AN BORD PLEANÁLA

04 MAR 2024

Summary Presentation on the Proposed MetroLink Route and its Potential Effect on AerCap House

Hines Real Estate Submission

ML1-JAI-RTA-ROUT\_XX-DR-Y-01027

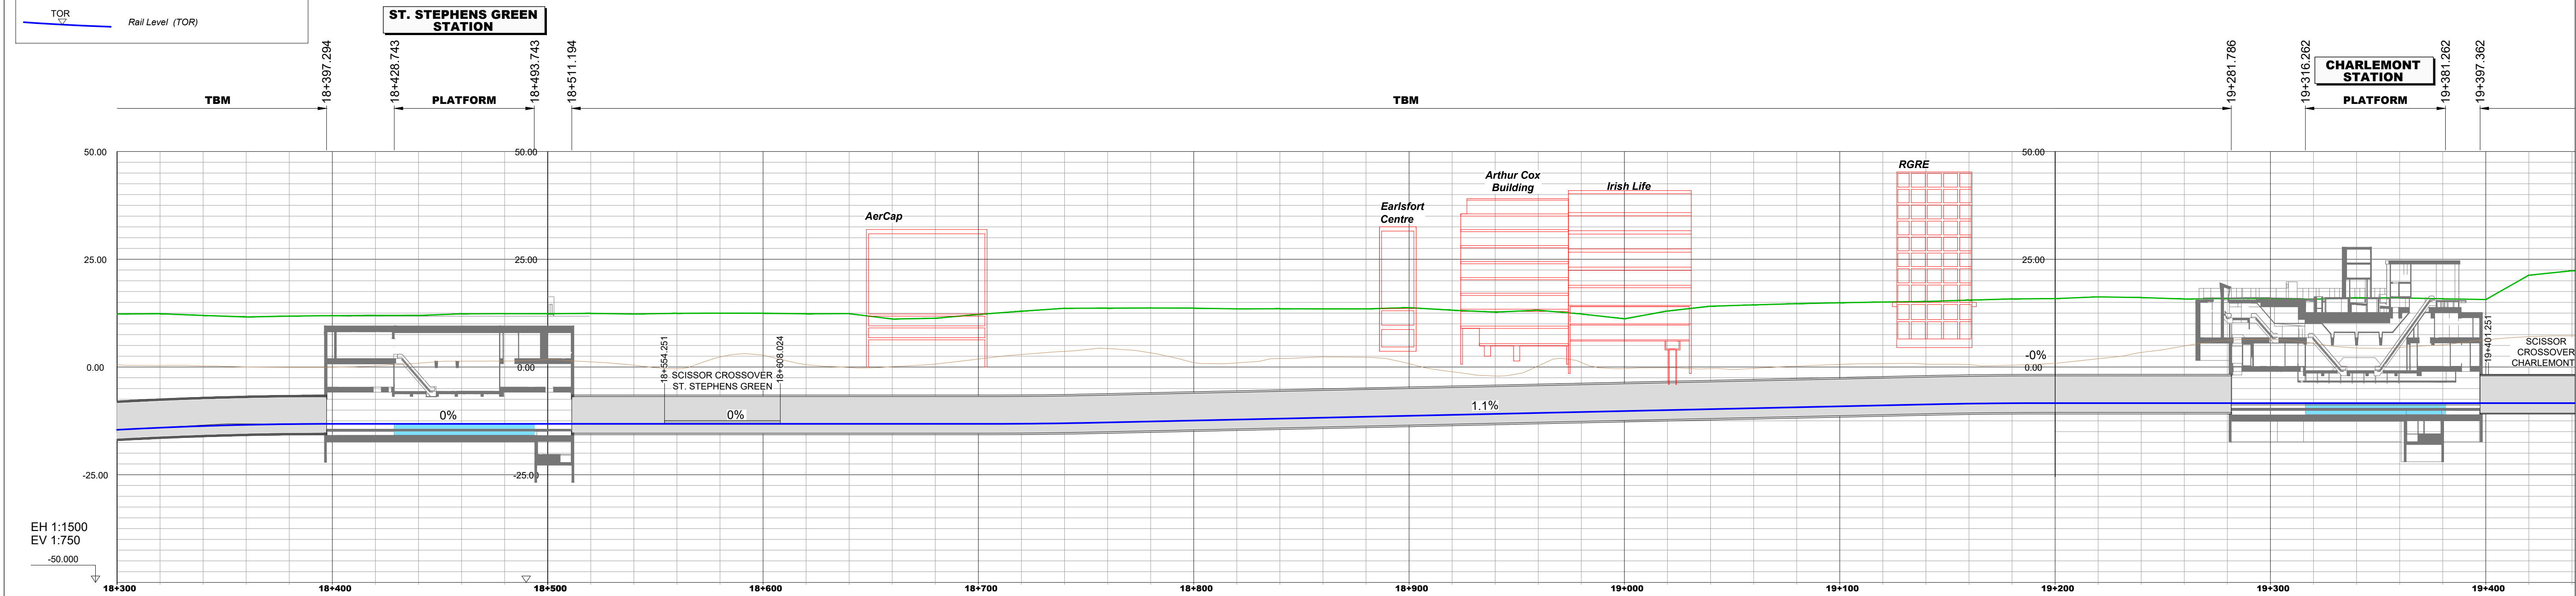
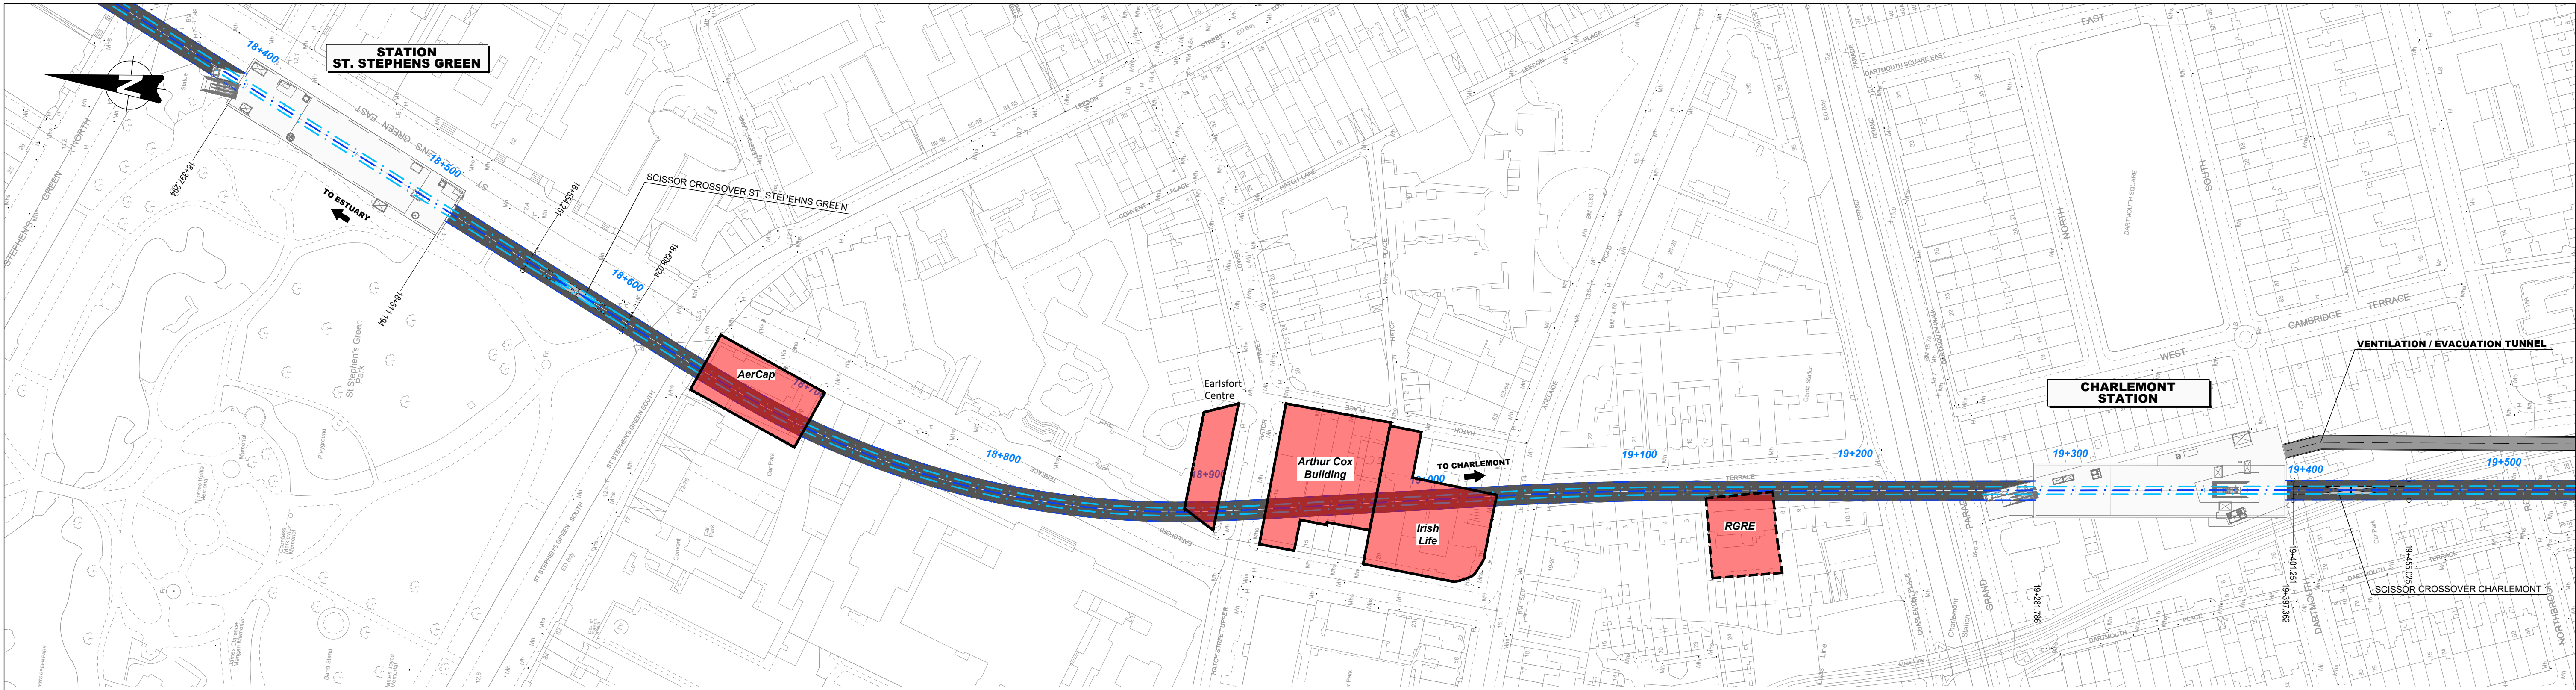
Based on our findings, we believe that if the Metrolink Tunnel is to pass under AerCap House, we require a detailed Phase 3 assessment using the correct building geometry and structural form to be completed and independently verified, ensuring the maximum damage caused to AerCap House is limited to 0.1mm cracking.

The proposed tunnel elevation may require to be lowered more than the current LOD downwards, i.e. more than the 10.0m indicated in the Wider Effects Report submitted as part of the application, considering the proximity and sensitivity of AerCap House.

- a) The Route of the Metrolink Tunnel should be diverted to avoid clashing with the existing substructure of AerCap House and damaging the existing building or
- b) The elevation of the Metrolink Tunnel should be lowered to the extent necessary to ensure that no damage will be caused to any part of AerCap House.
